KITTITAS COUNTY

County Survey review of Boundary Line Adjustment 16-00010

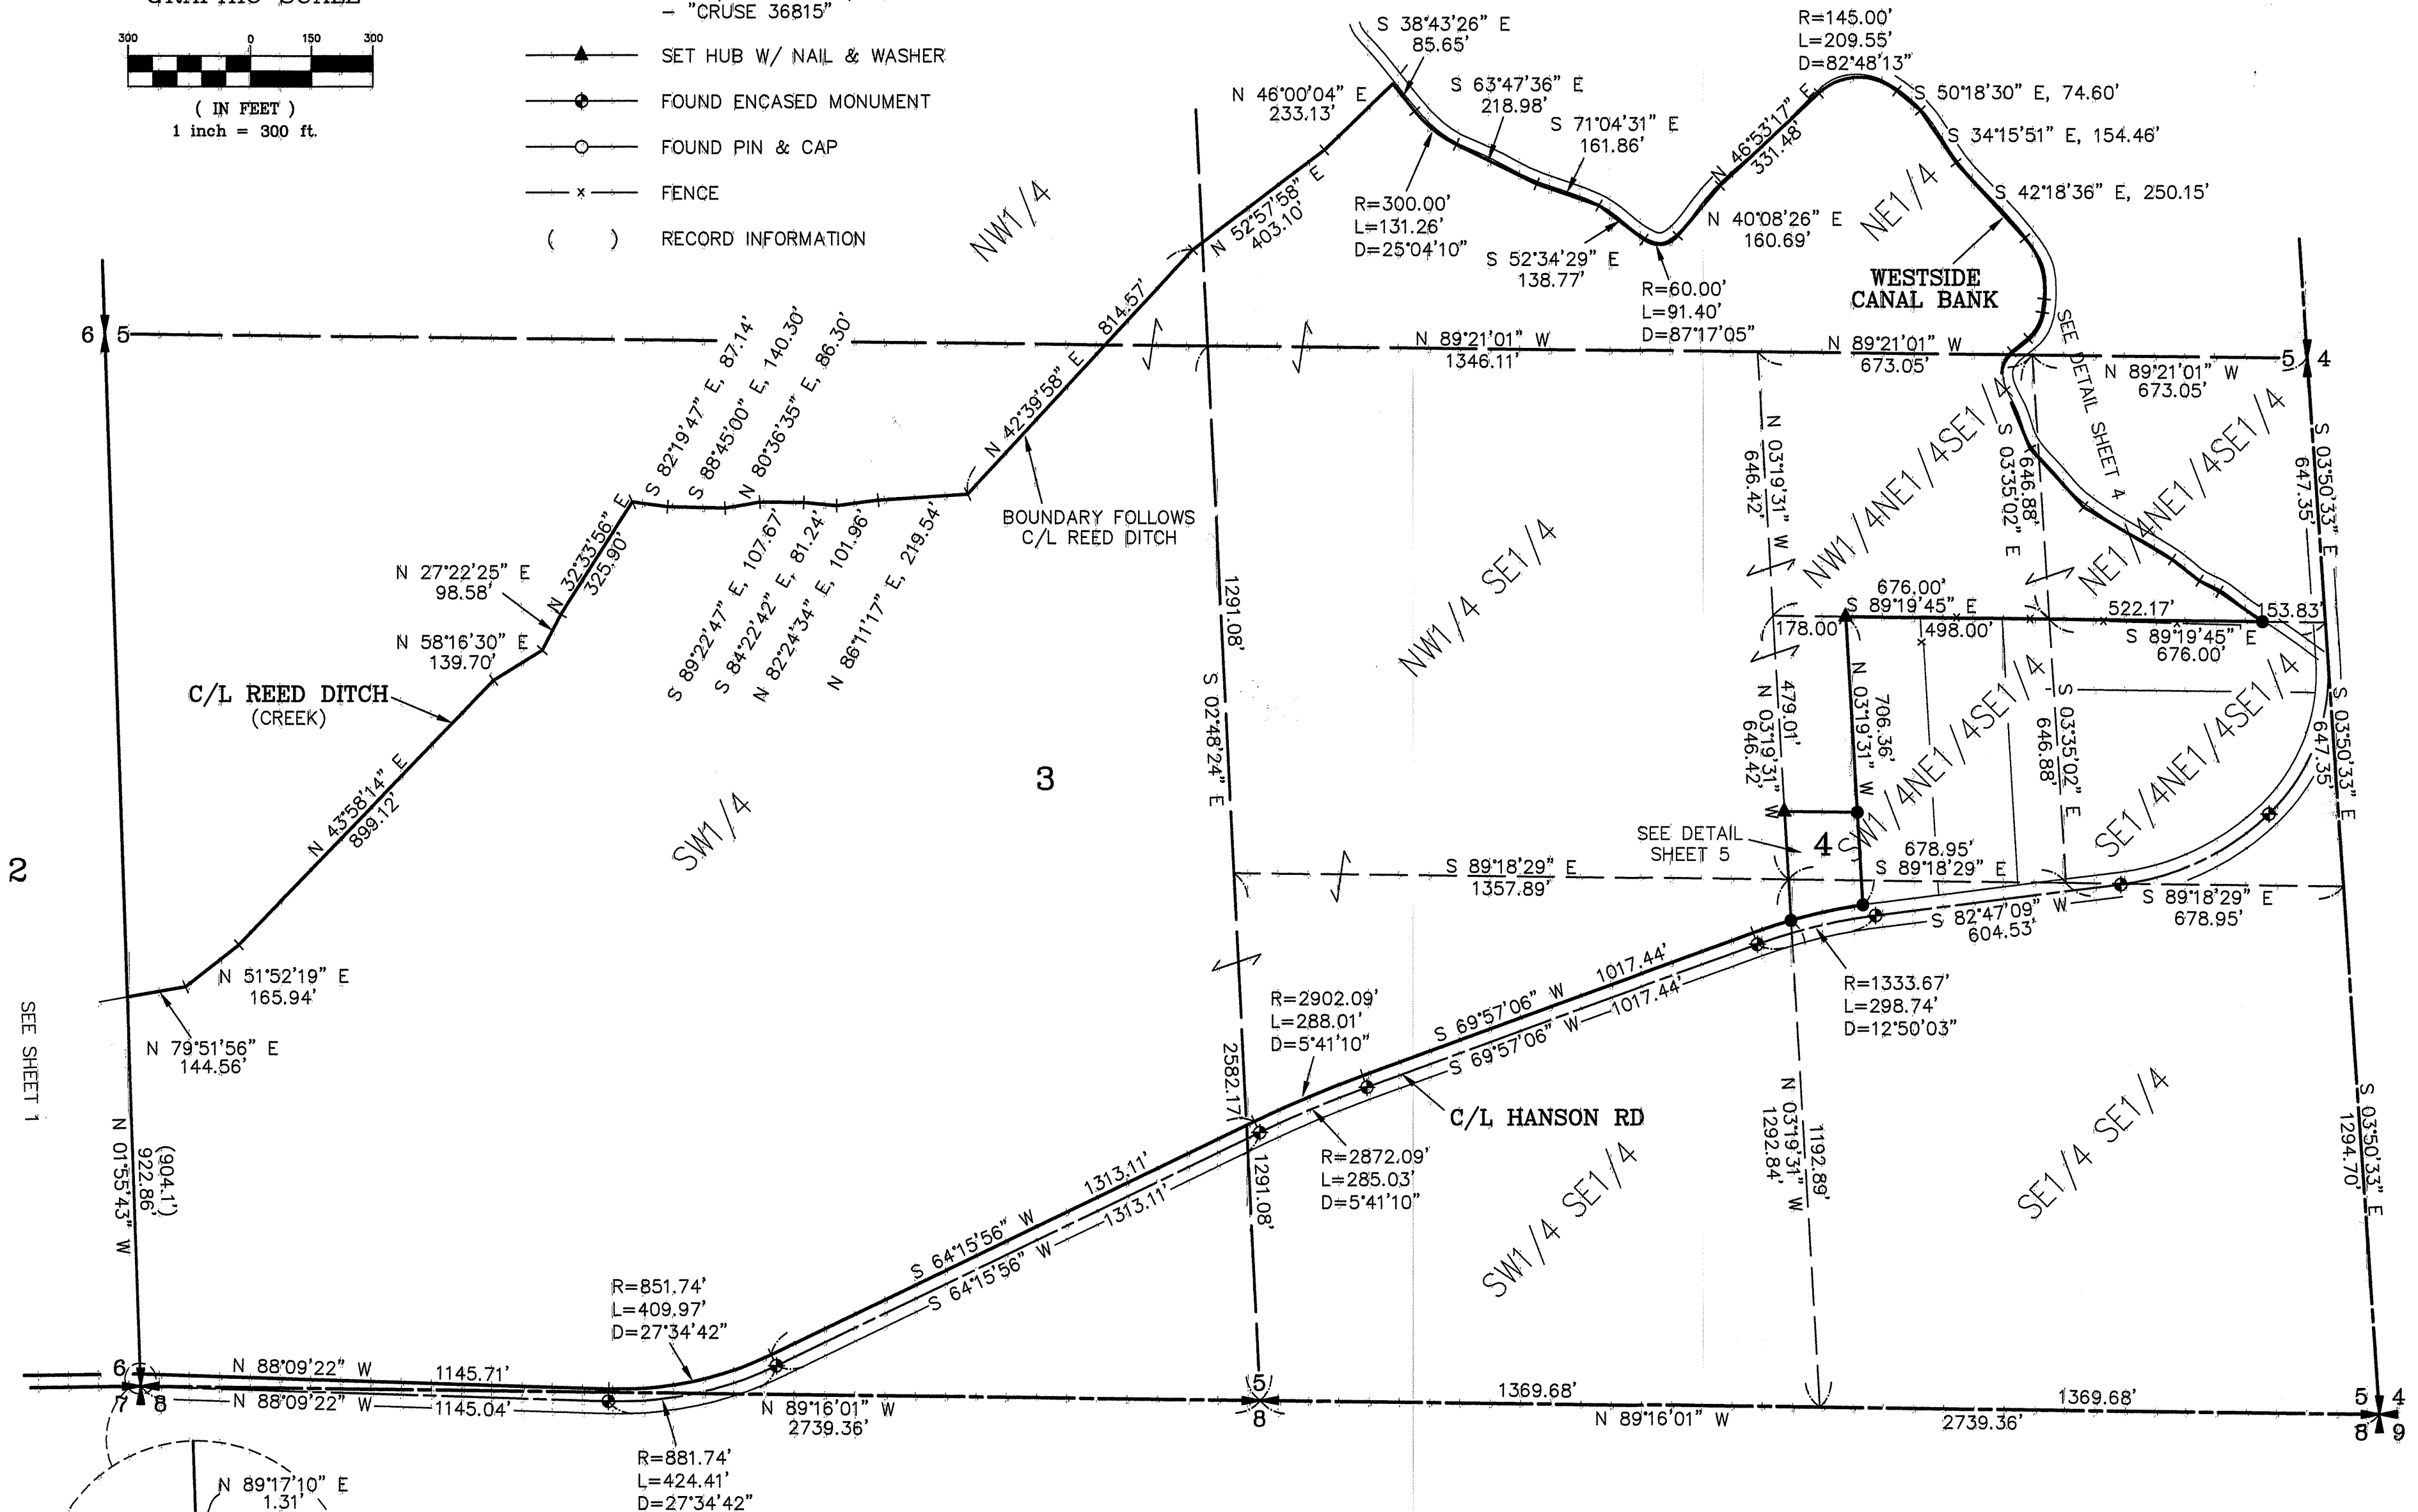
1. Sheets that show Hanson Rd or Weaver Road., should include the road name, ownership (County R/W), width, and surfacing material.
2. Sheet 2, the parcel line North of Lot 4, should be labeled with the distance of 479.08.

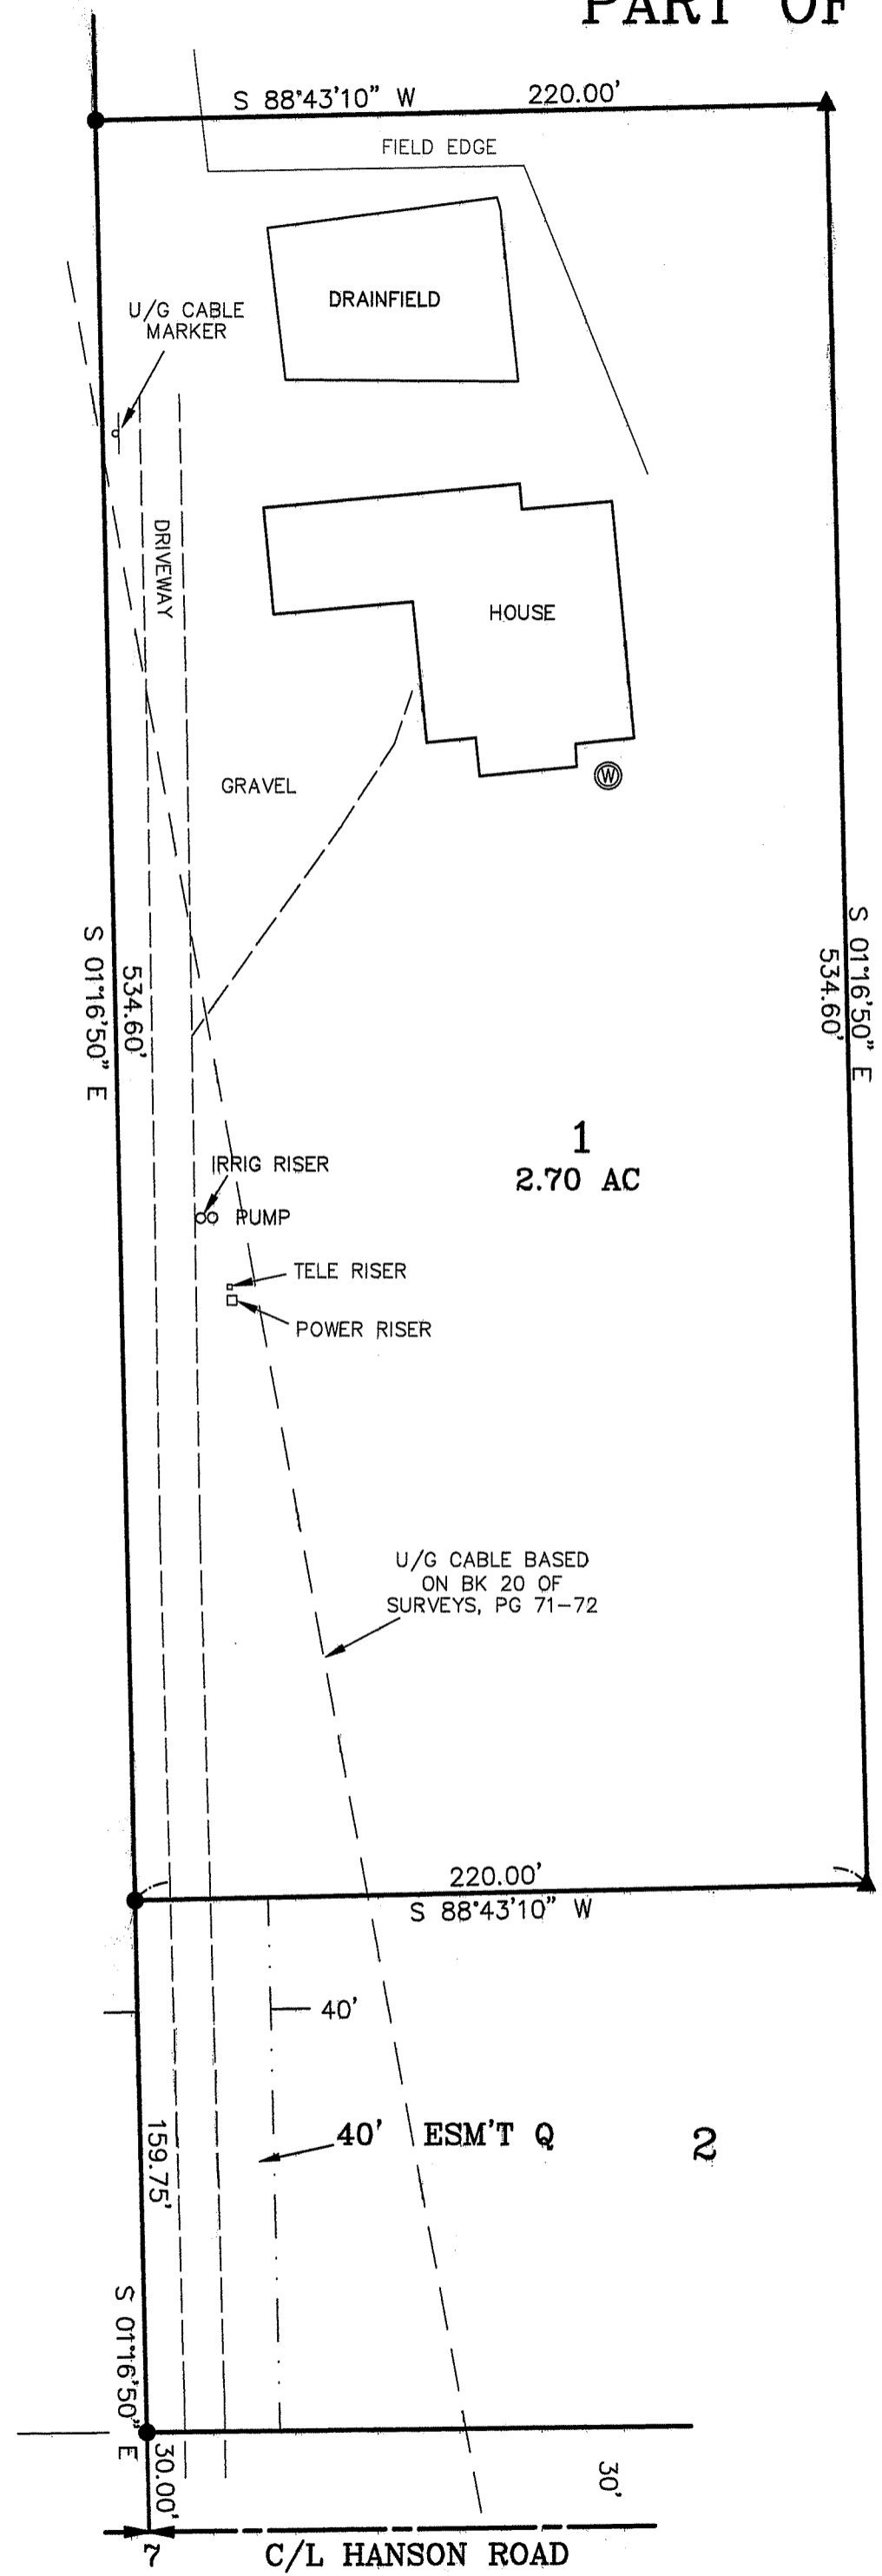
3. Sheet 3 includes "Easement Q", which needs to include the purpose as well as the recording number, or a blank space to be completed upon recording. As a BLA (or survey) has no grantee/grantor signatures, an easement cannot be created via the BLA, and must be made via separate document. One option would be to include the statement "proposed easement – to be filed via separate document". The legal description for the easement also contains a minor typo.

4. Sheet 3 lists accepted section corner codes that would be unfamiliar to the layperson. These respective corners should be labeled graphically with the corner codes, OR the note should be changed to reflect common corner descriptions, rather than corner codes.

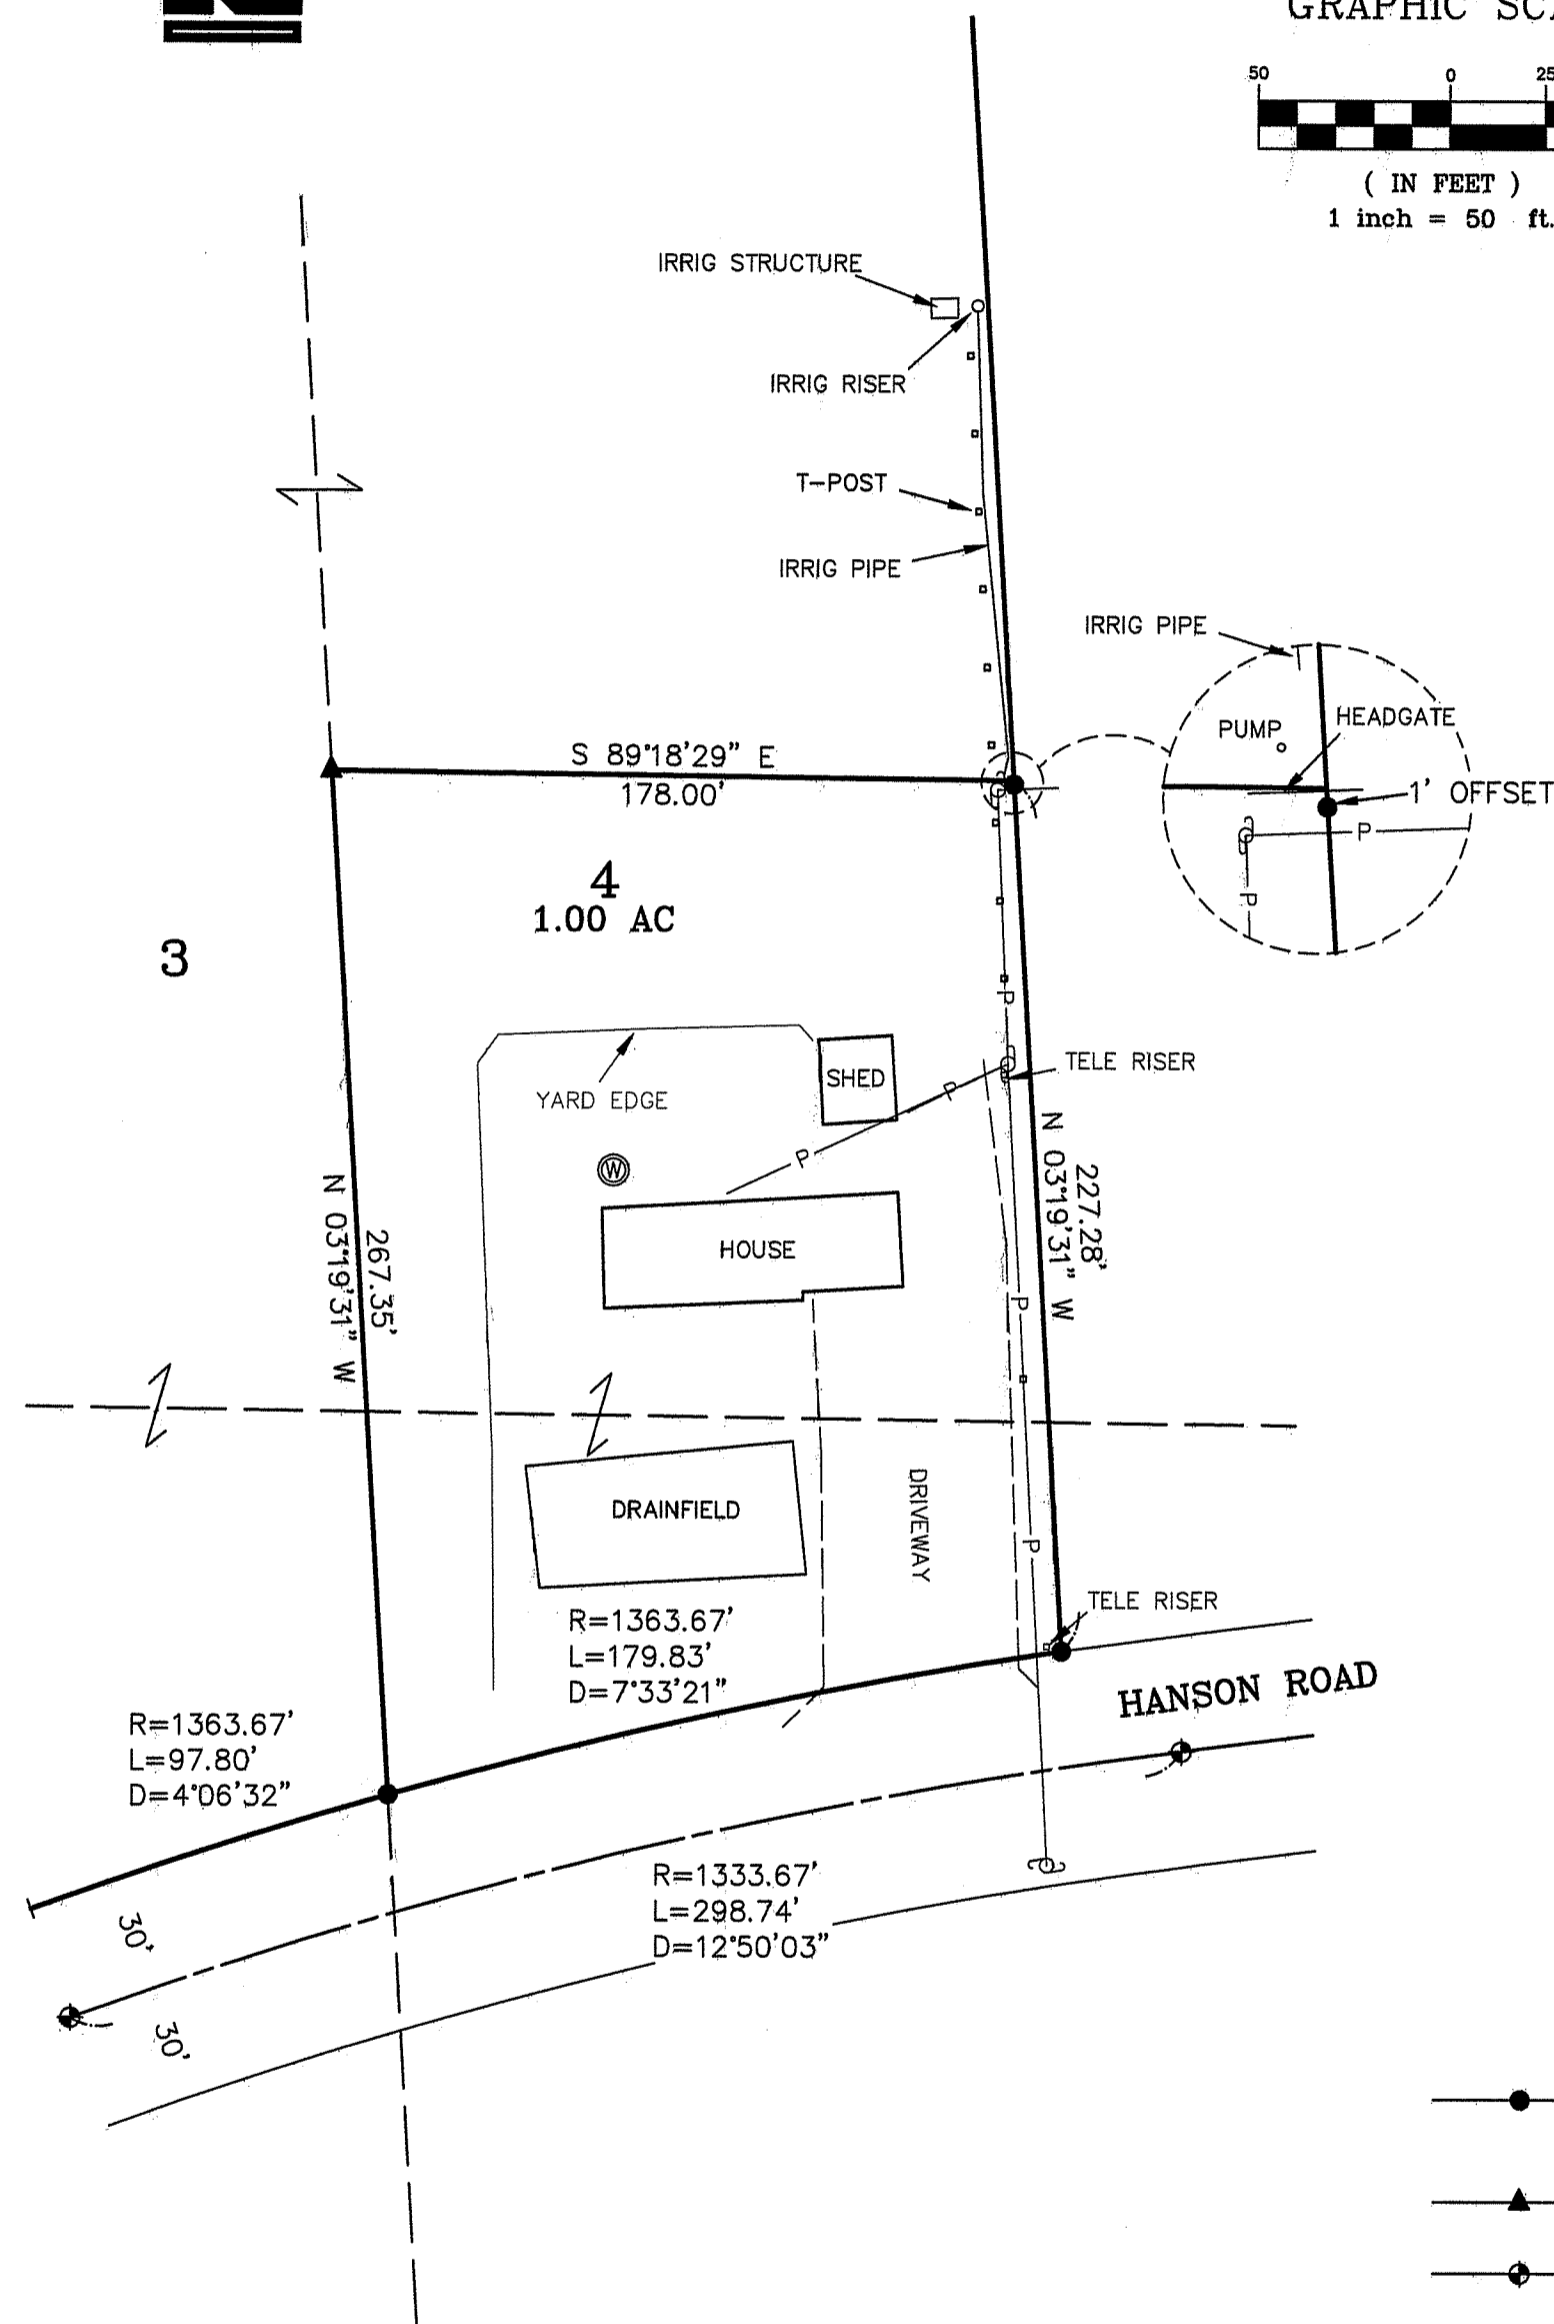
5. The dashed line near the centerline of Westside Canal is assumed to be the deed centerline. If so, please add a label showing this.
6. On sheet 5, label the dashed line as "previous boundary".

7. On Sheet 5, the existing legal descriptions should be taken from legal documents, not from AFN's.
8. On Sheet 5, the legal descriptions (to be created), should be labeled as "Proposed Legal Descriptions"
